PLANNING CONSULTATION RESPONSE

Application No	2026/0652
Proposal	2026 0652 Variation of Condition 2 for Design Siting Parking Areas and Landscaping of Unit 1 of 2024 0292 Royd Moor House Farm Royd Moor Road Thurlstone
Address	Royd Moor House Farm Roys Moor Road Thurlstone
Date of Consultation Reply	090926
Consultee	Tony Wiles Senior Conservation Officer

PLOT 1 - ROYD MOOR ROAD SIDE Elevation

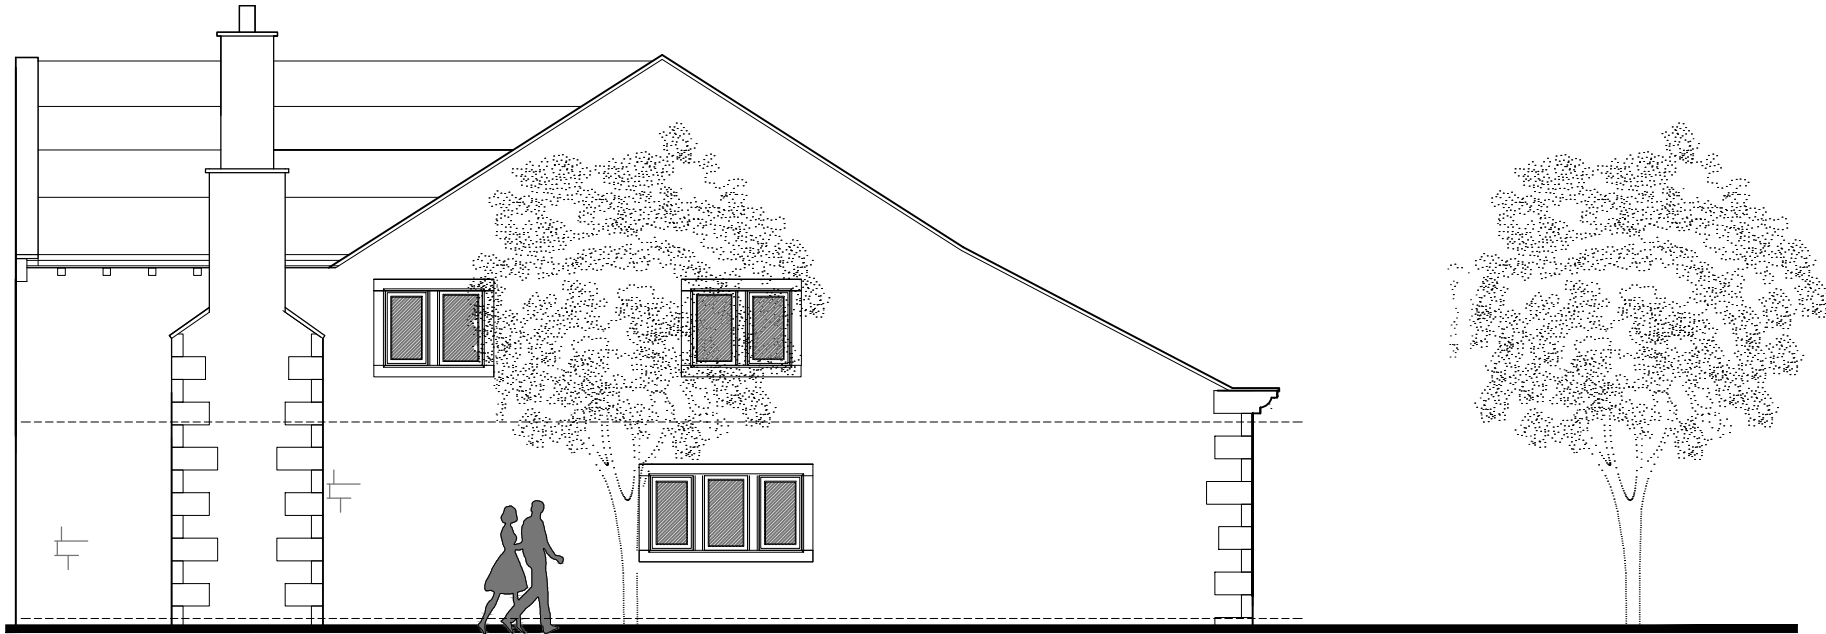
This application seeks approval for a minor variation to the approved plans under application 2024/0292. The proposed changes relate to Plot 1 and comprise a modest northward shift of the approved footprint, revisions to the parking areas, and minor alterations to the approved design. The design changes are limited in scope and include the omission of a side window facing Royd Moor Road, together with amendments to the rear elevation.

PLOT 1 - REAR Elevation

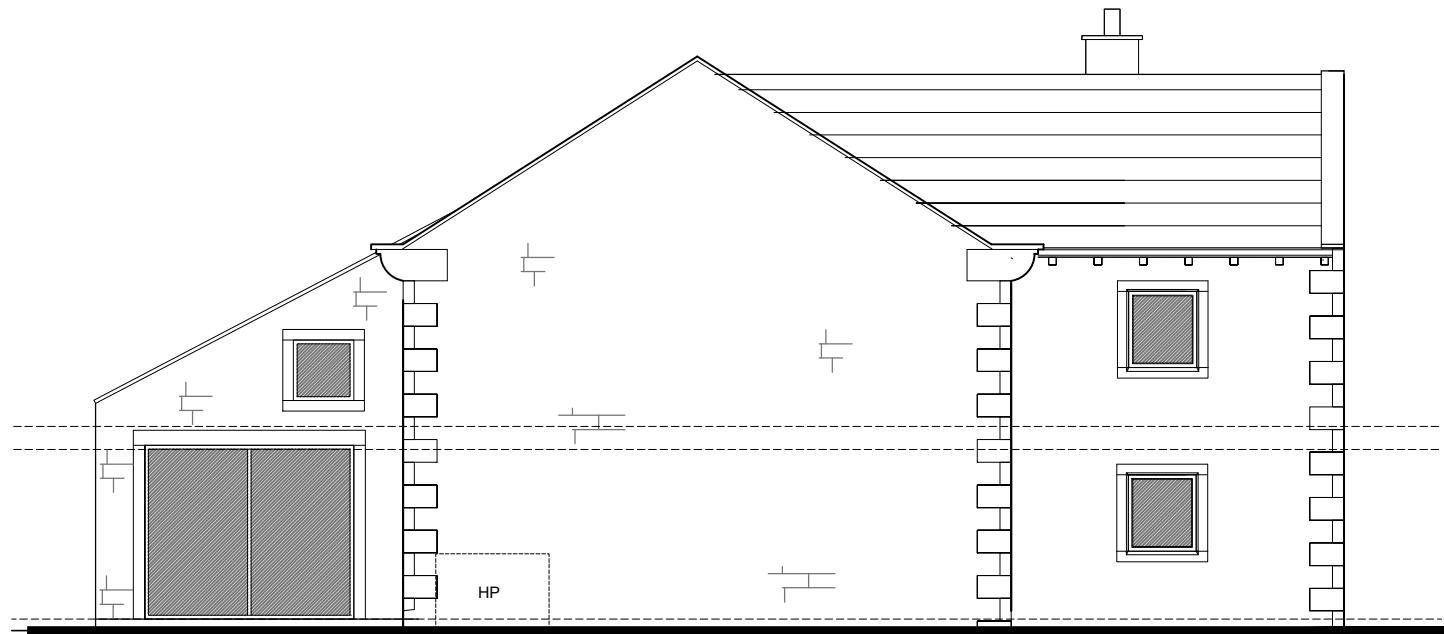
The principal design change to the rear involves replacing the previously approved glazed gabled projection with a simpler pitched catslide roof arrangement, incorporating a large rooflight to provide improved daylight to the space below. In conservation terms, this is a modest alteration and does not materially alter the overall form, scale or character of the approved dwelling.

From the perspective of the listed buildings at Royd Moor House Farm, the revised catslide arrangement is considered to be a sympathetic and appropriate design response. It would sit comfortably within the approved form of the dwelling and would be barely perceptible in the wider
